Re: EXHIBITION OF STATE SIGNIFICANT DEVELOPMENT APPLICATION SSD-9346594

PROPOSAL:	LOT 103 DP 866530
ADDRESS:	9 WHYALLA PLACE, PRESTONS NSW 2170

Thank you for the opportunity to comment on the proposed State Significant Development (SSD) for the construction and operation of a Waste Treatment Facility at 9 Whyalla Place, Prestons NSW 2170.

GROUND FLOOR PLAN - PROPOSED
Scale 1:100

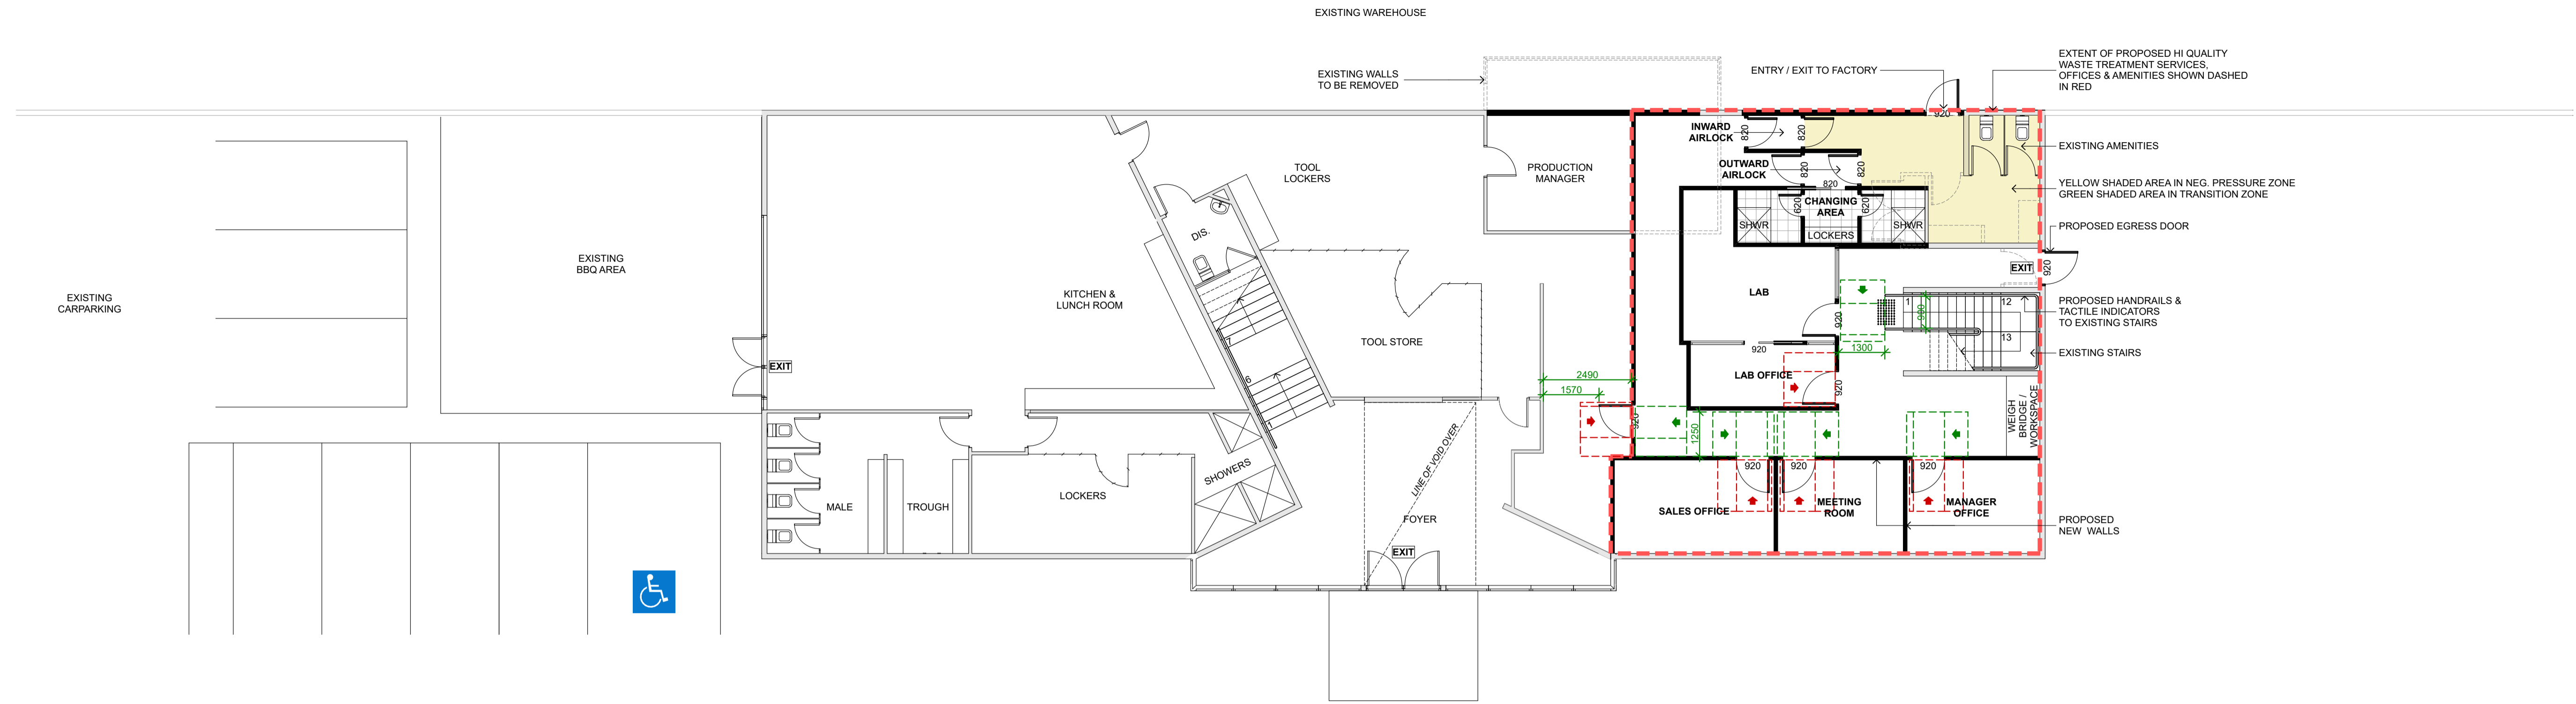
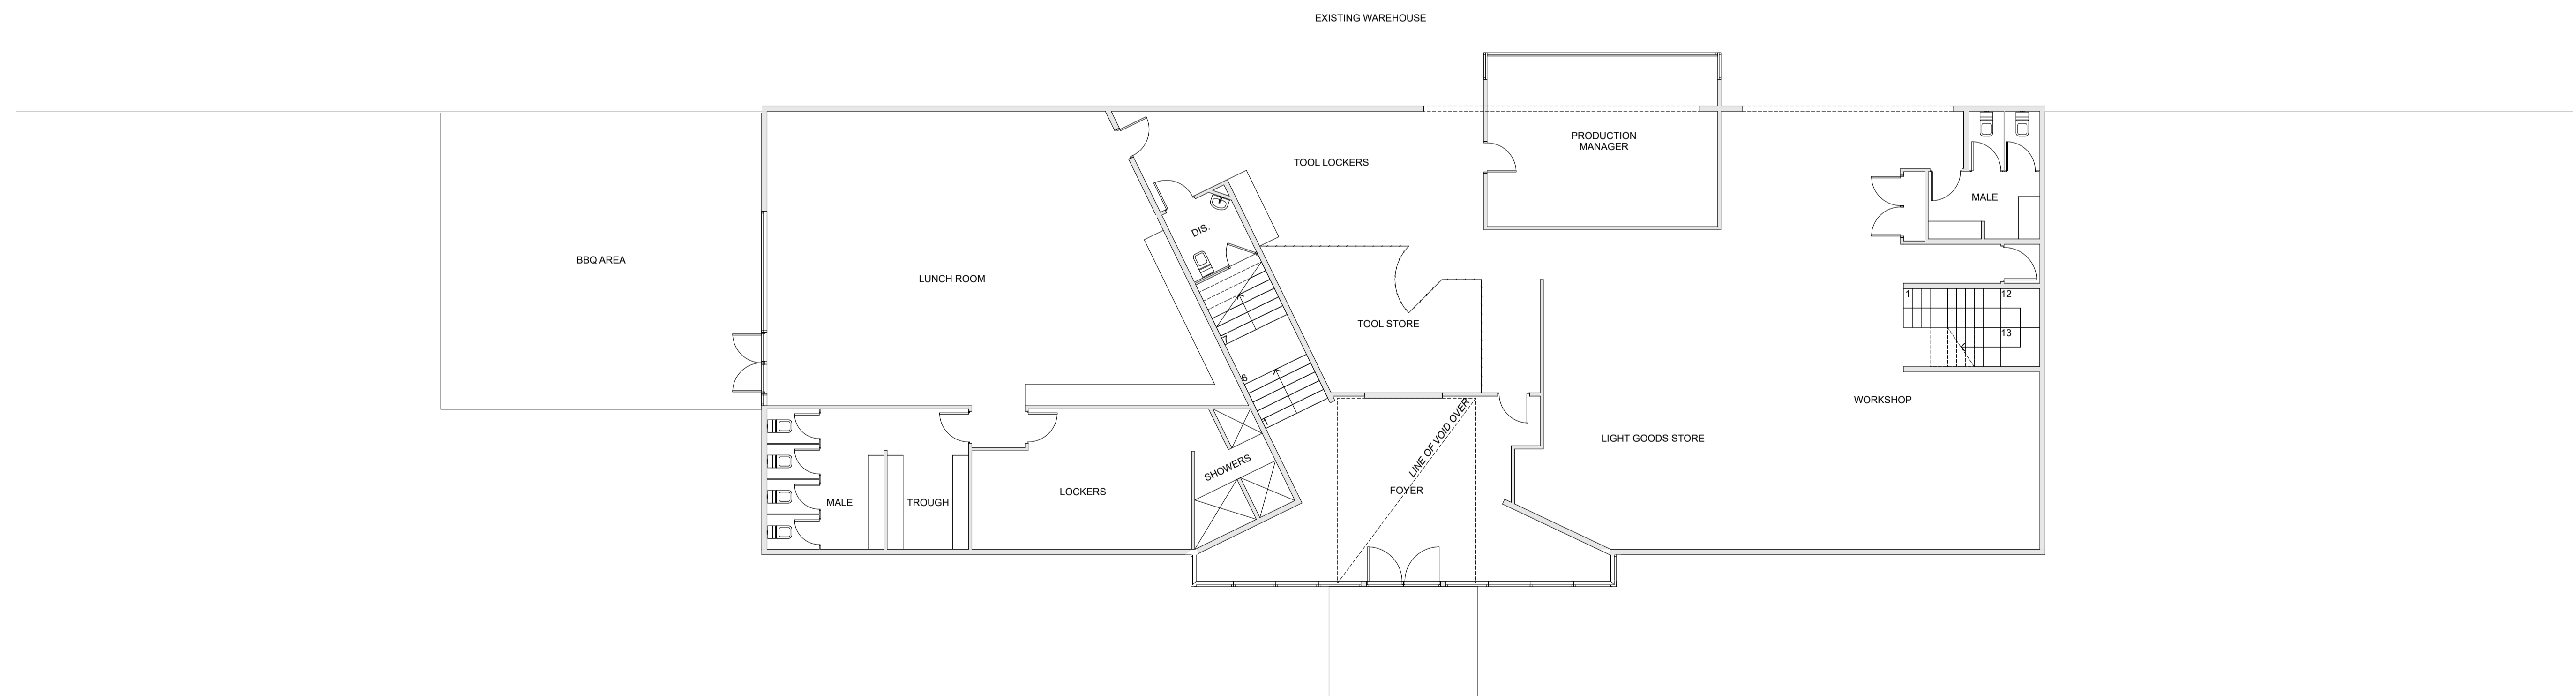
As per NSW Government updated flood-prone land package (commenced on 14 July 2021) and Council's Development Control Plan, the proposed waste treatment facility is considered as sensitive and hazardous development. The flood planning level for a sensitive and hazardous development is the Probable Maximum Flood (PMF) level, which is 24.5m AHD. However, the submitted design drawings indicate that the ground floor level of the proposed waste treatment facility is 23.2m AHD, which is much lower than the required level.

- All floor levels shall be no lower than the Probable Maximum Flood (i.e., 24.5m Australian Height Datum).
- The structure shall be constructed from flood compatible building components below the Probable Maximum Flood (i.e., 24.5m Australian Height Datum).

- An engineer's report shall be required to certify that the structure can withstand the forces of floodwater including debris and buoyancy up to and including the Probable Maximum Flood (i.e., 24.5m Australian Height Datum).

CREATED BY X.D  
 APPROVED BY M.S  
 SHEET 01 / 06

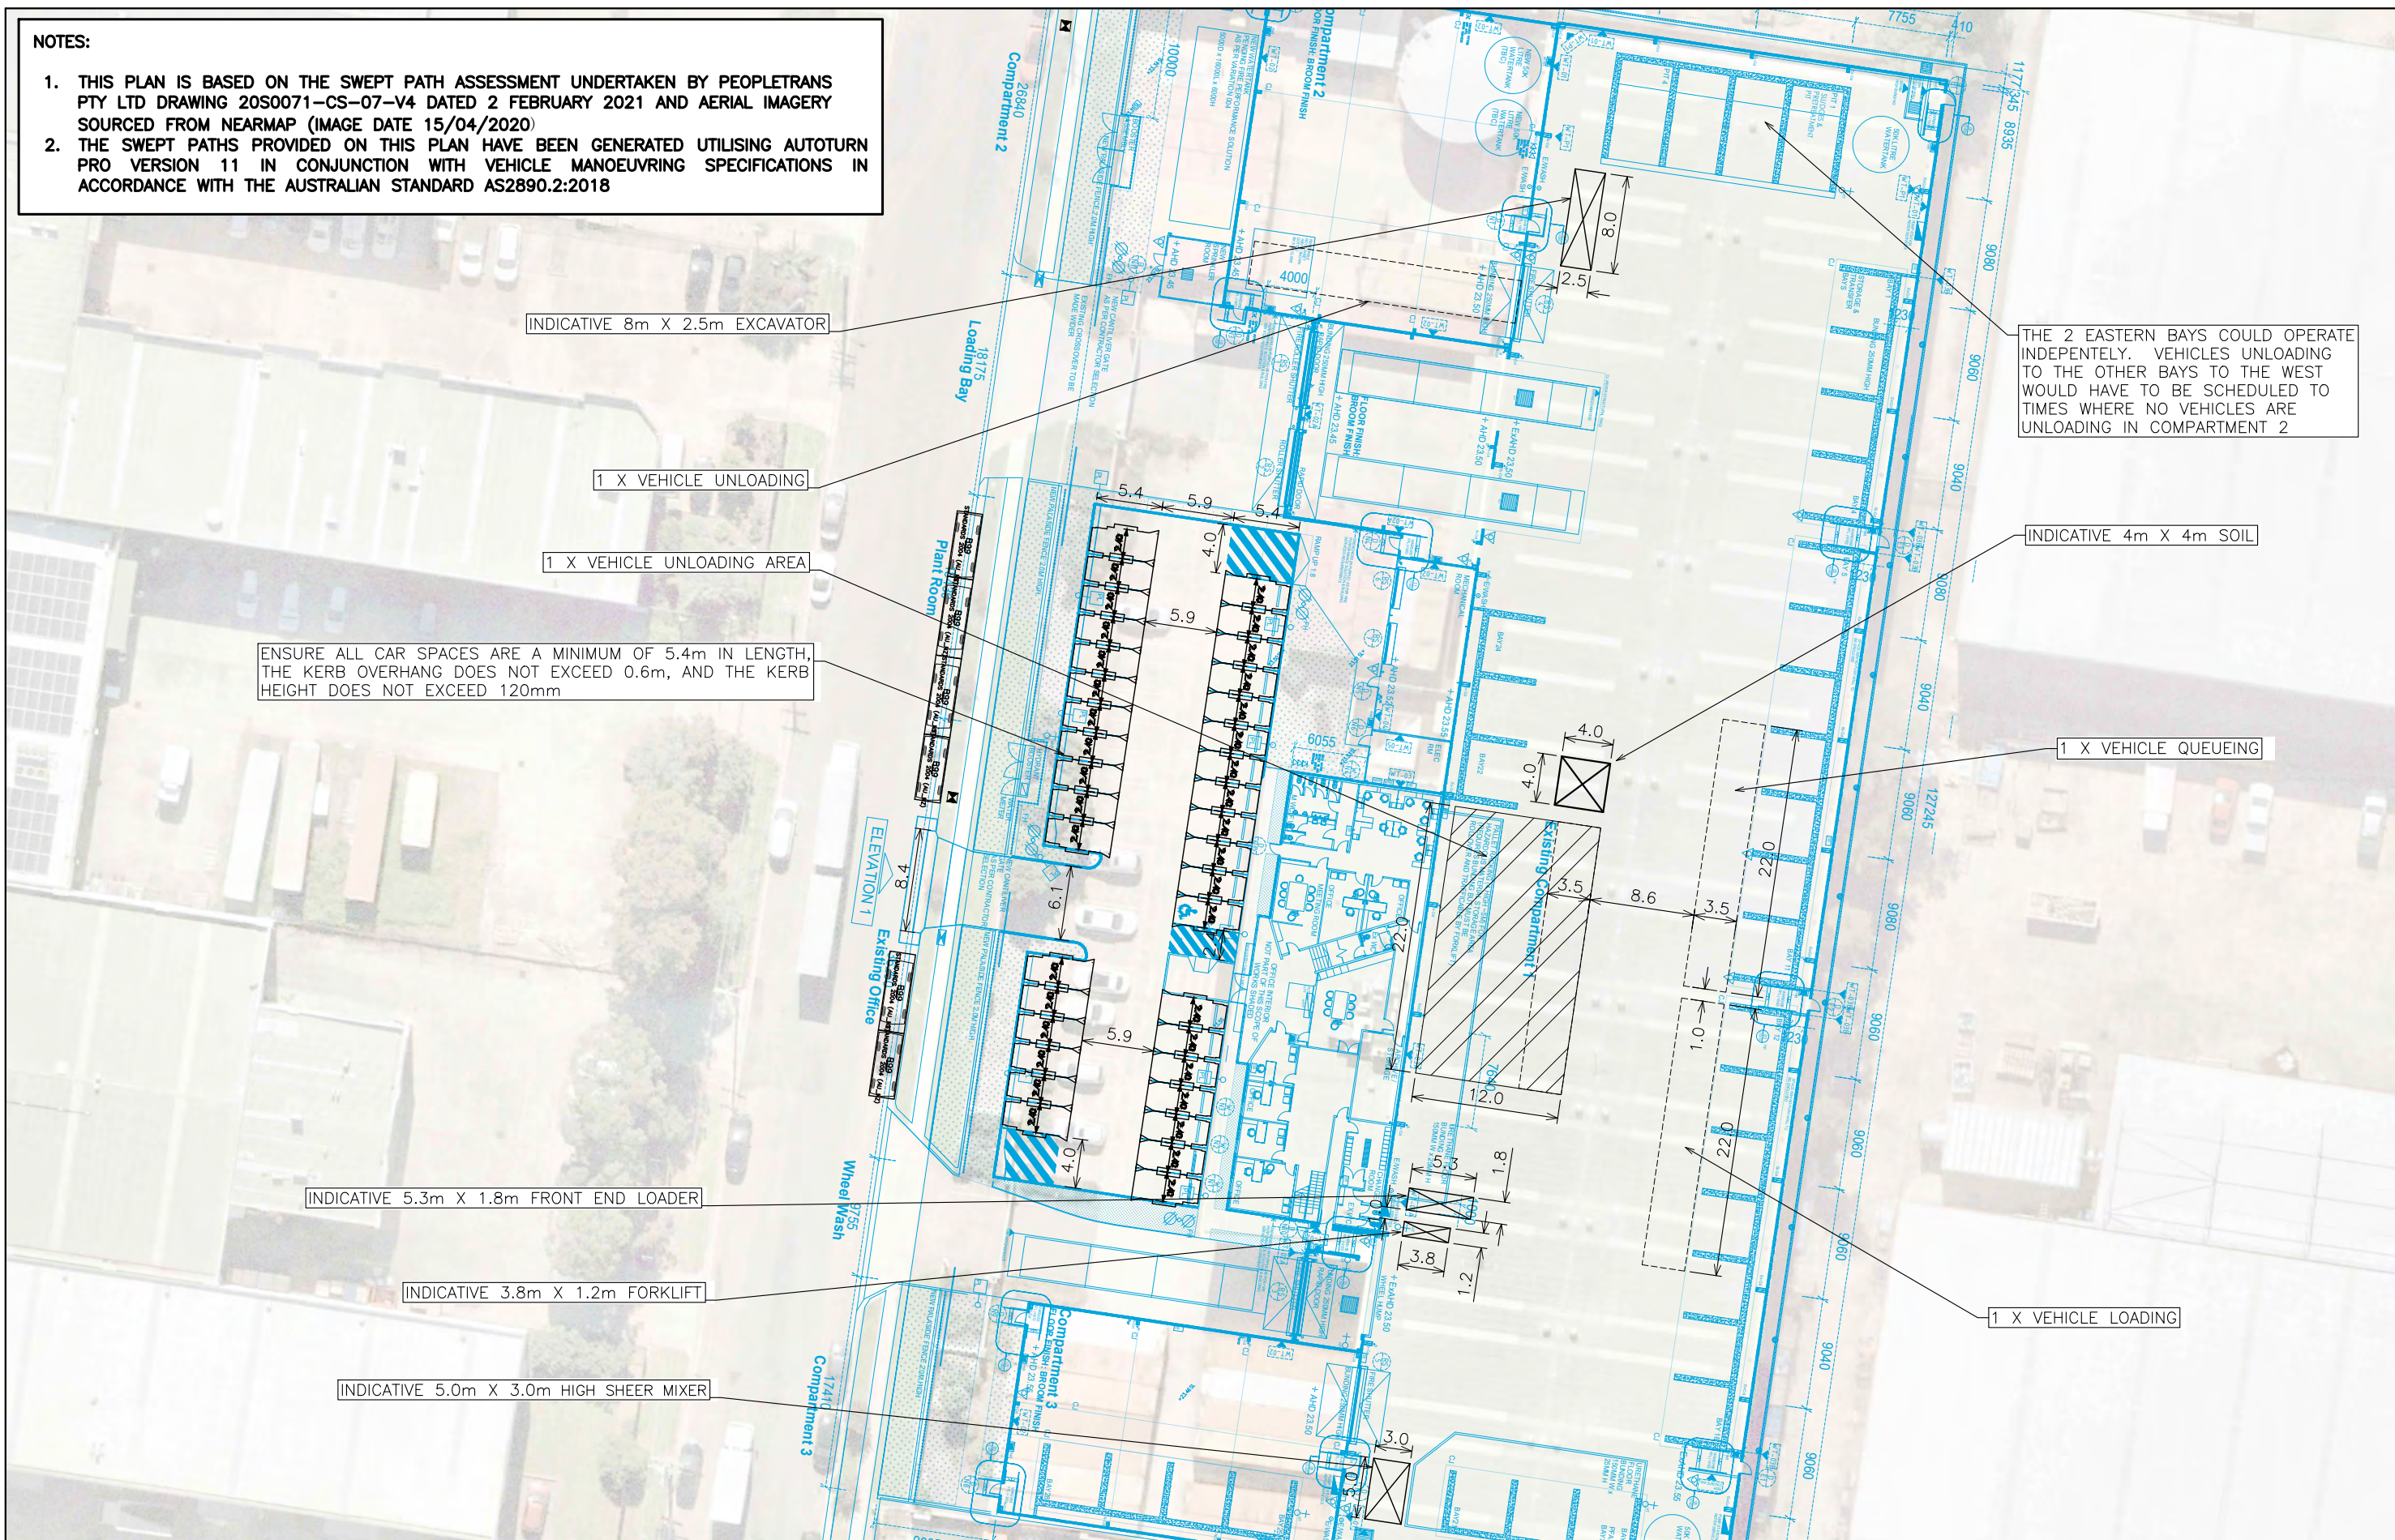
It is noted that no permanent dedicated on-site loading space is proposed. A queue area of 4 truck length is provided on site. The OPTM is to prepare and ensure that no vehicle accessing the subject site is queuing on Whyalla Place.
